Application No: FG/82/21/PL
Site Address: 11 Ferring Marine Ferring BN12 5PP
Description of works: Variation of condition imposed under FG/127/19/HH relating to approved plans.

Thank you for your internet representation made on 3rd June 2021 which has been recorded as an objection with the comments as follows:

PROPOSED
ELEVATIONS AND
MAIN SECTION

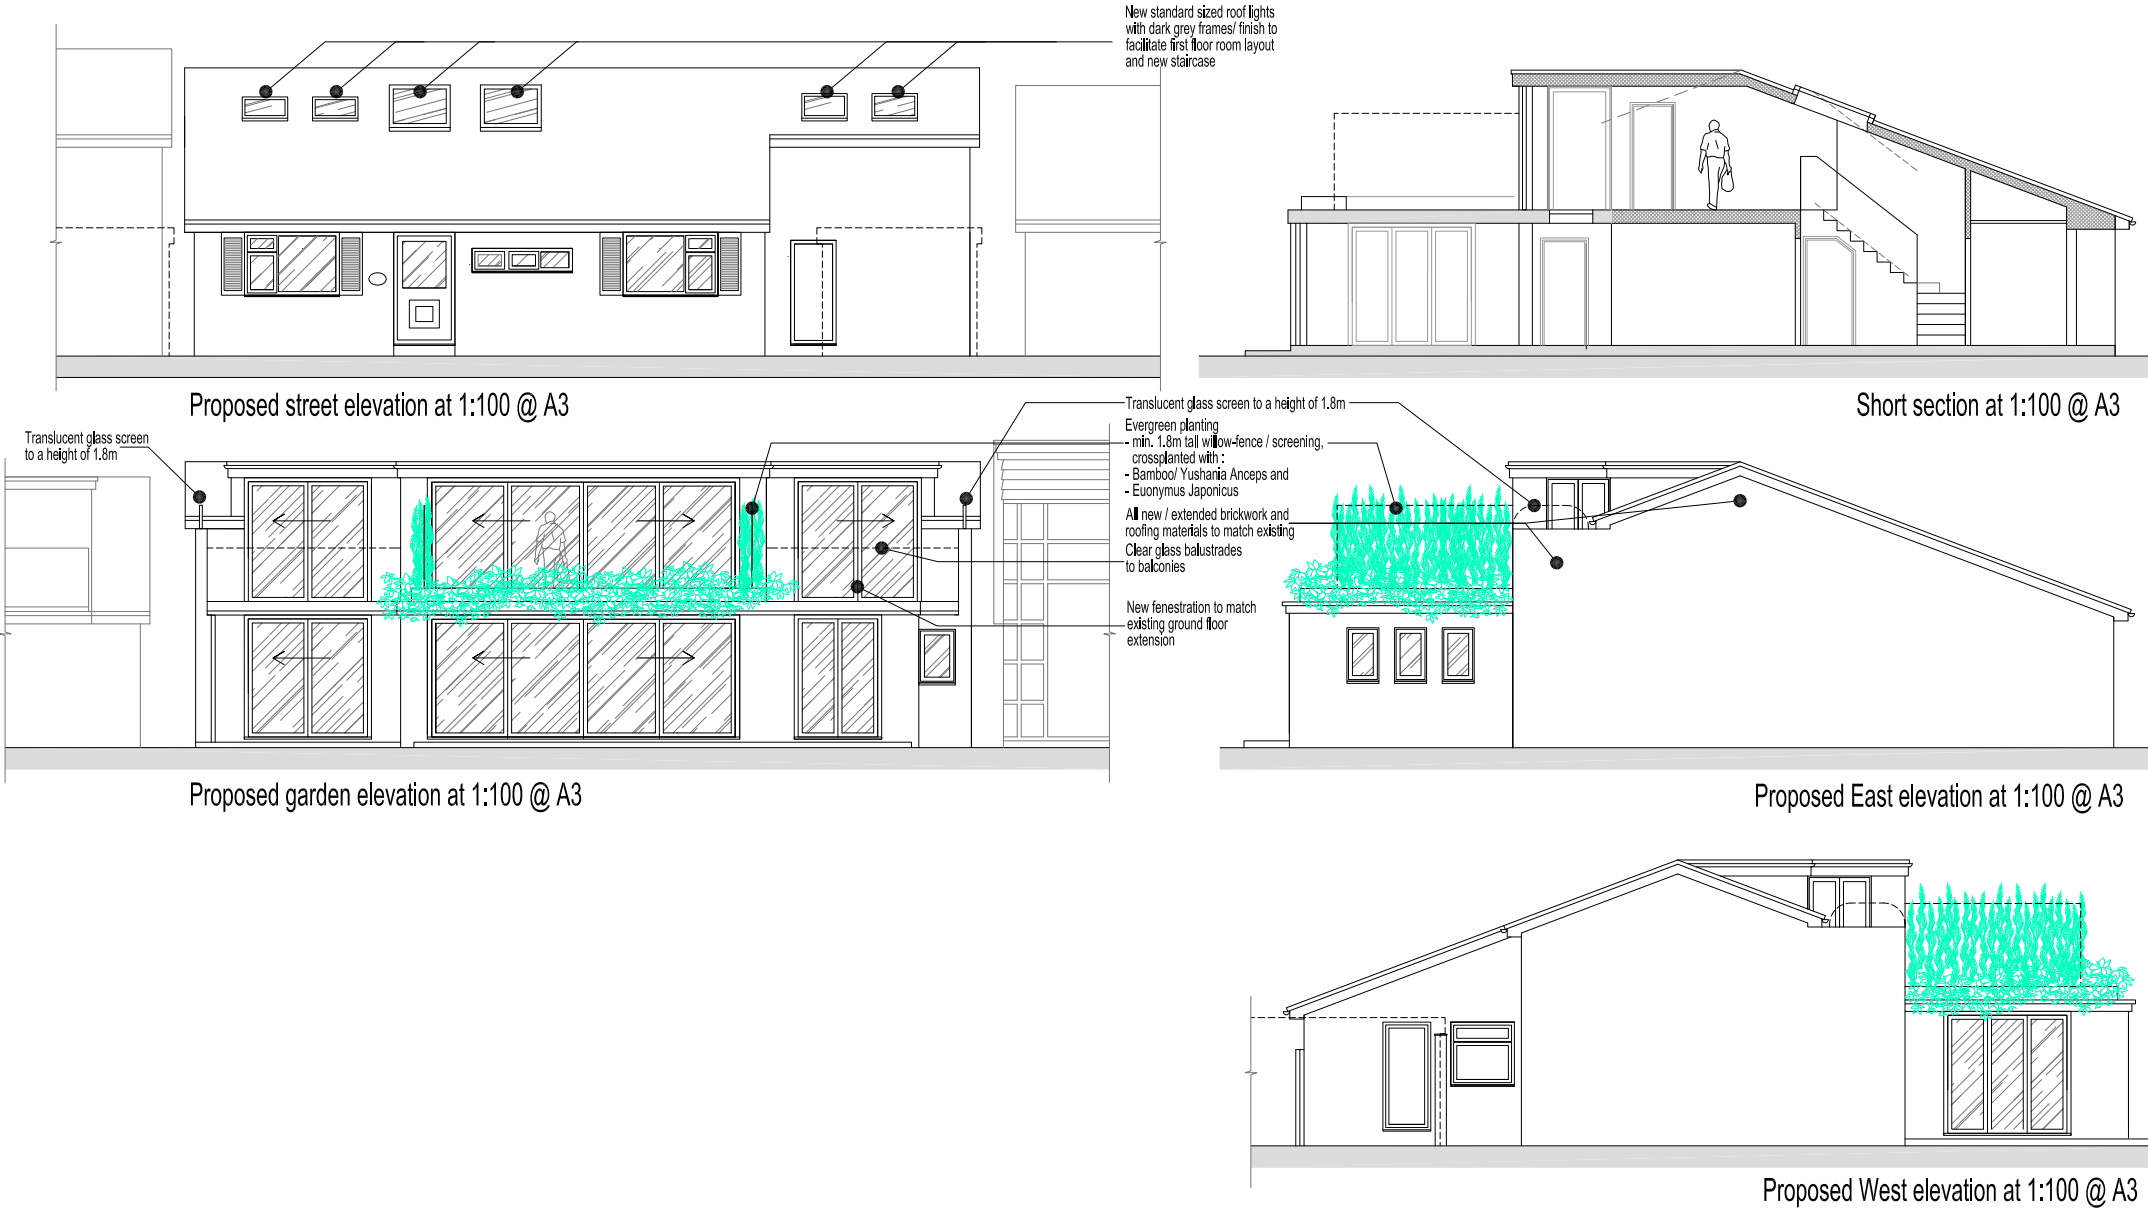
My previous objection had a data error, I wanted to close by saying that the past approved planning drawing no P5 C dated 27/08/19 clearly shows a screen preventing access out onto the 'green roof not a usable terrace' why has this been removed from these drawings? There is a specific condition on Application Ref: FG/127/19/HH not to use the flat roof as a roof terrace. The planning says "The green roof area (shown on plan P3 Rev C) of the extension hereby permitted shall not be used as a balcony, roof garden or similar amenity area." If this variation of a condition is approved the area will certainly be used. I have noticed today that wooden decking has already been installed in preparation. After reading a few of the other objections I would strongly recommend that a senior buildings control surveyor inspect the site as a matter of urgency to check for other obvious breaches that have been mentioned.
